### **McLean - Hodgen Subdivision, MS-24-3**

Please accept the following comments from El Paso County Public Health regarding the 2-lot minor subdivision project referenced above:

MCLEAN SUBDIVISION
BEING A PART OF THE NORTHEAST QUARTER OF SECTION 28,
TOWNSHIP 11 SOUTH, RANGE 66 WEST OF THE 6TH PRINCIPAL MERIDIAN,
COUNTY OF EL PASO, STATE OF COLORADO.

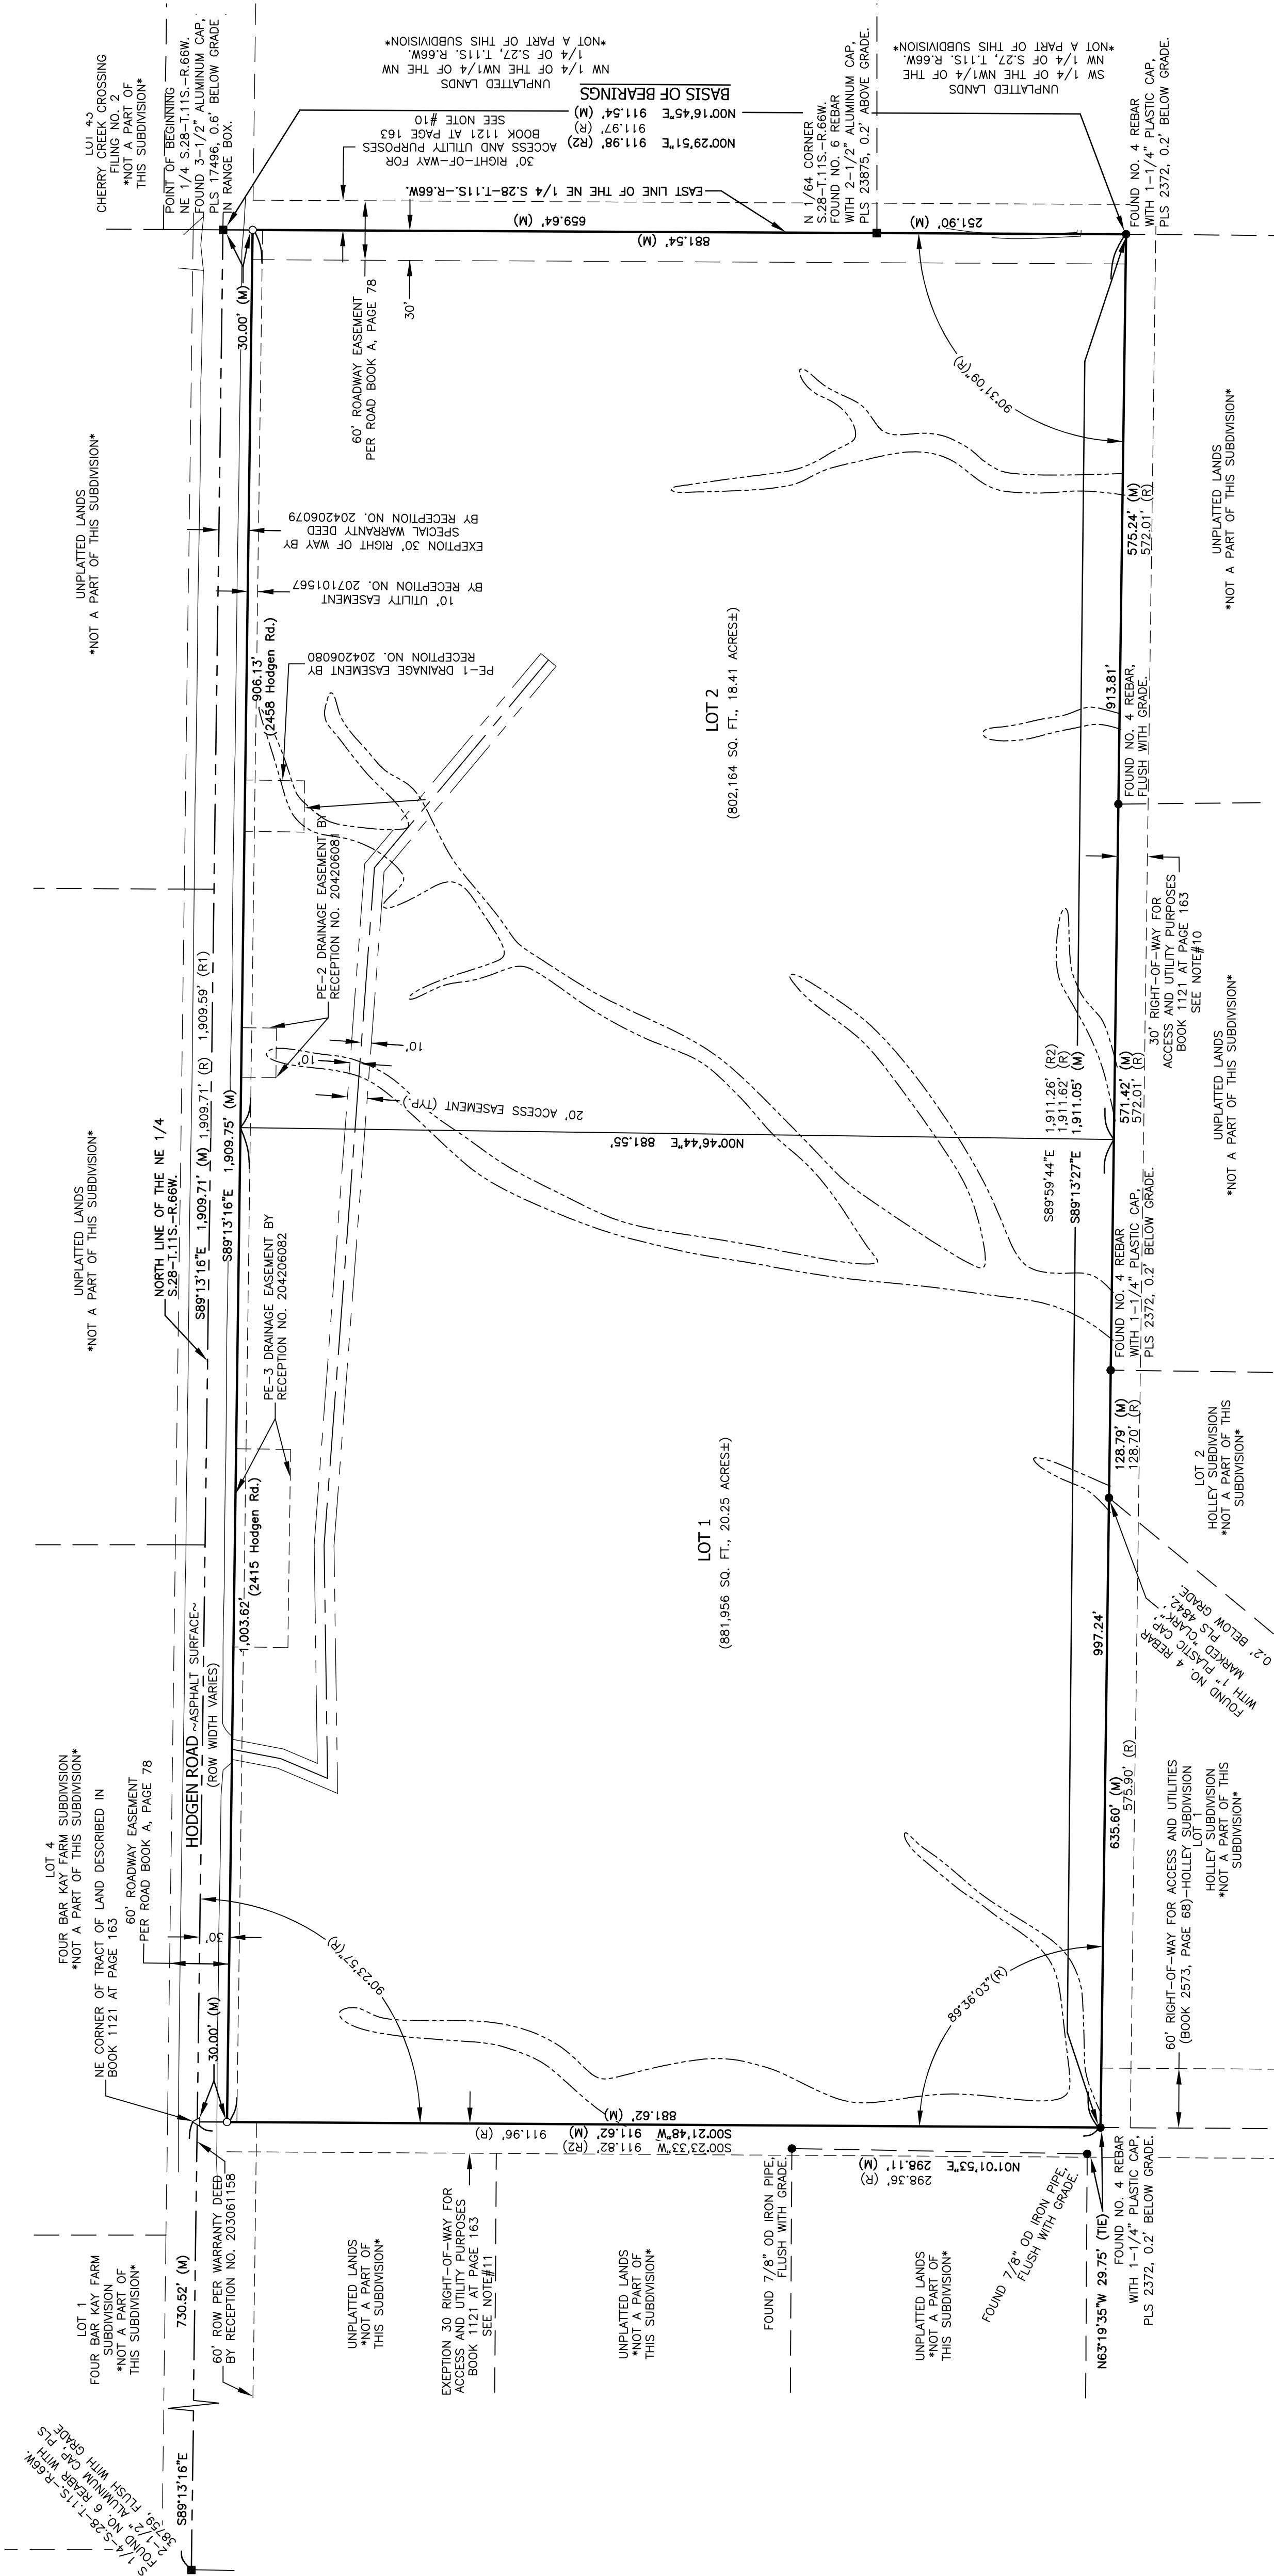
**Note:** The RESPEC report indicated there were 4 lots, but 2 were on the Plat Drawing. The approval from El Paso County Public Health is for 2 lots only.
